Snape Parish Council submits the below comments for your information and consideration with regard to the DCO for Scottish Power Renewables (SPR) development of an offshore wind farm and substation (EN 010077/78) Ref 20023749/50.

TITLE
SNAPE MITIGATION SCHEME (A1094 - FARNHAM ROAD) - PRELIMINARY DESIGN

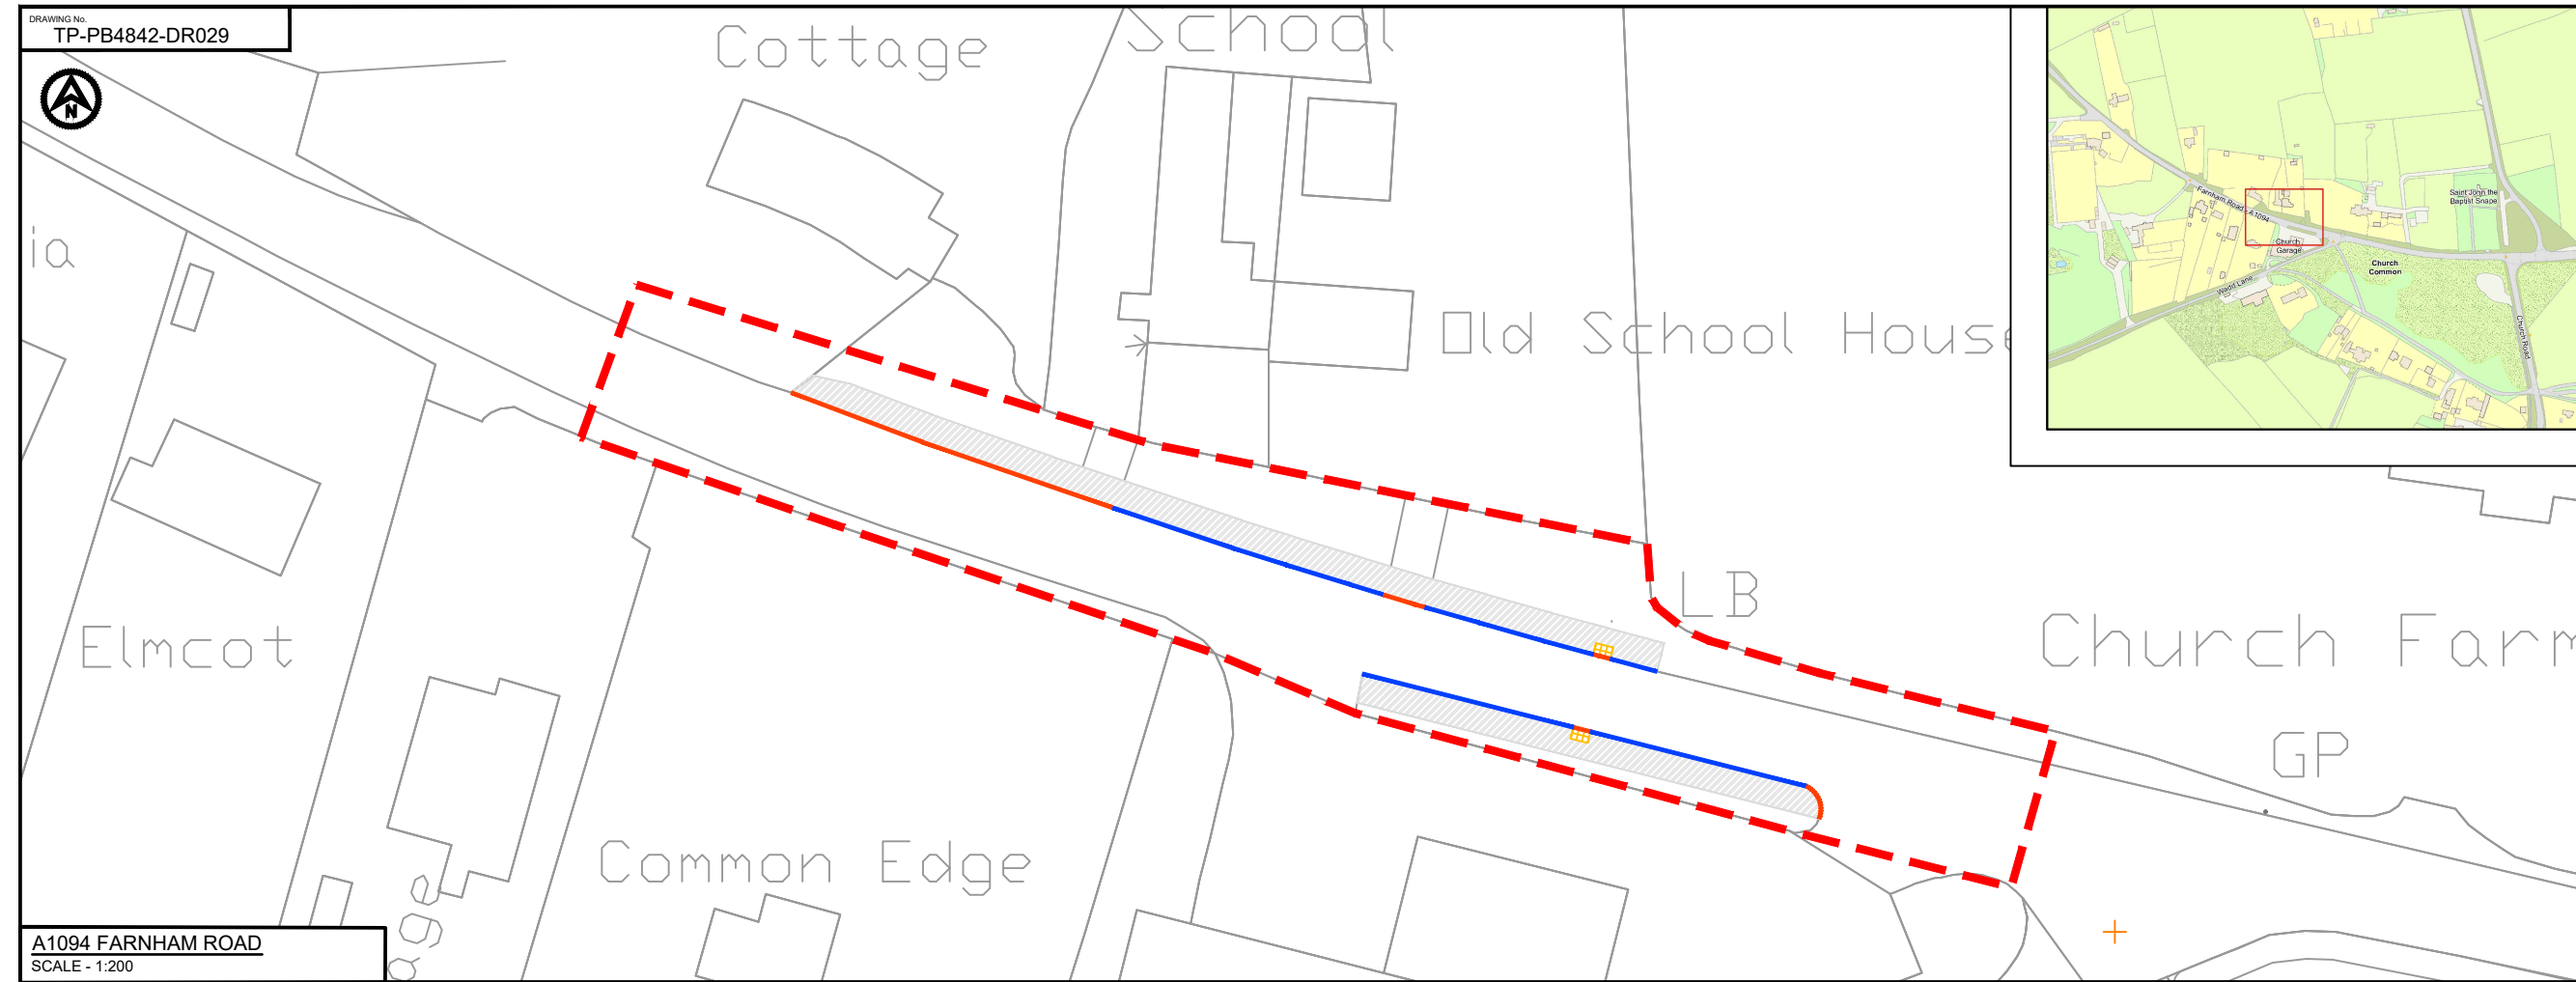
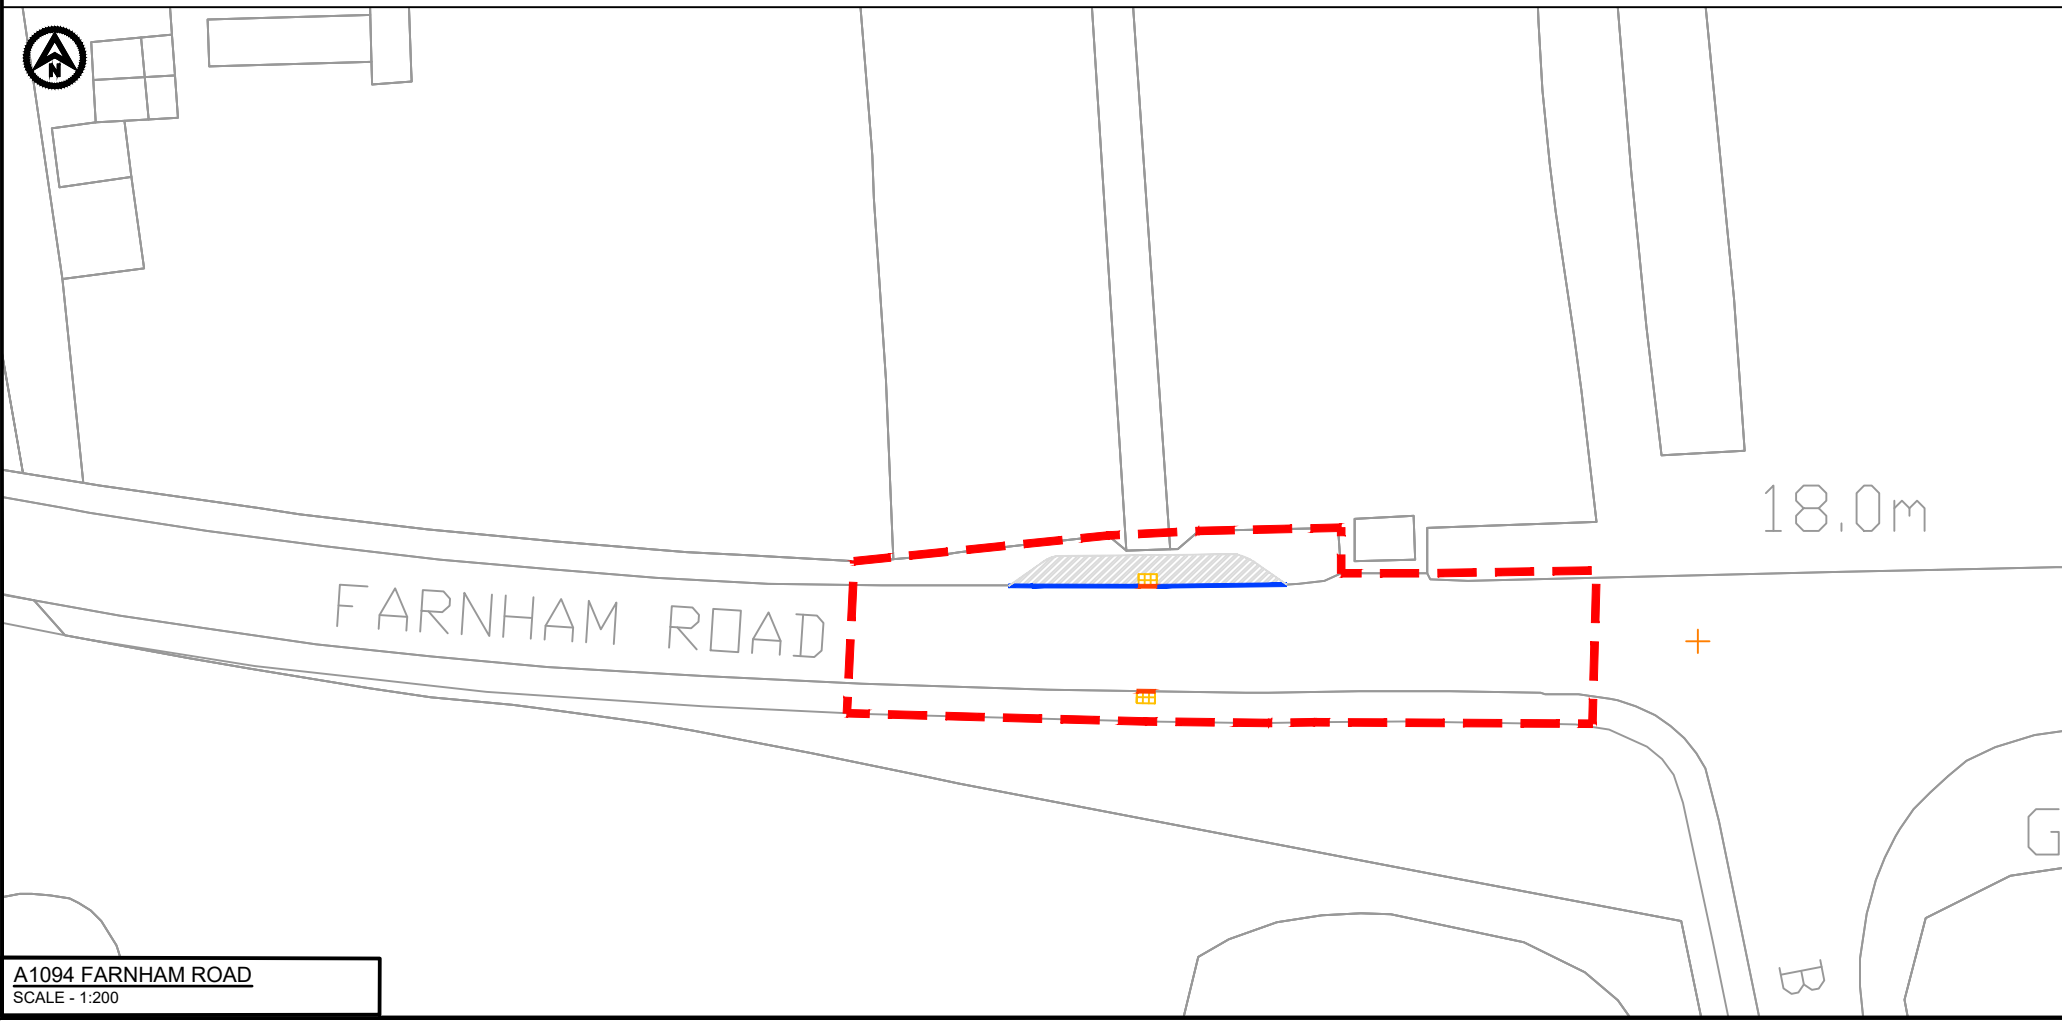
3.2 The DCO response to concerns about access to local facilities such as the local Church sited on the A1094 being accessed from a car park by pedestrians across the main road, an existing traffic hazard, does recognise the issue and offers some mitigation without addressing the underlying issue of increased traffic volumes.
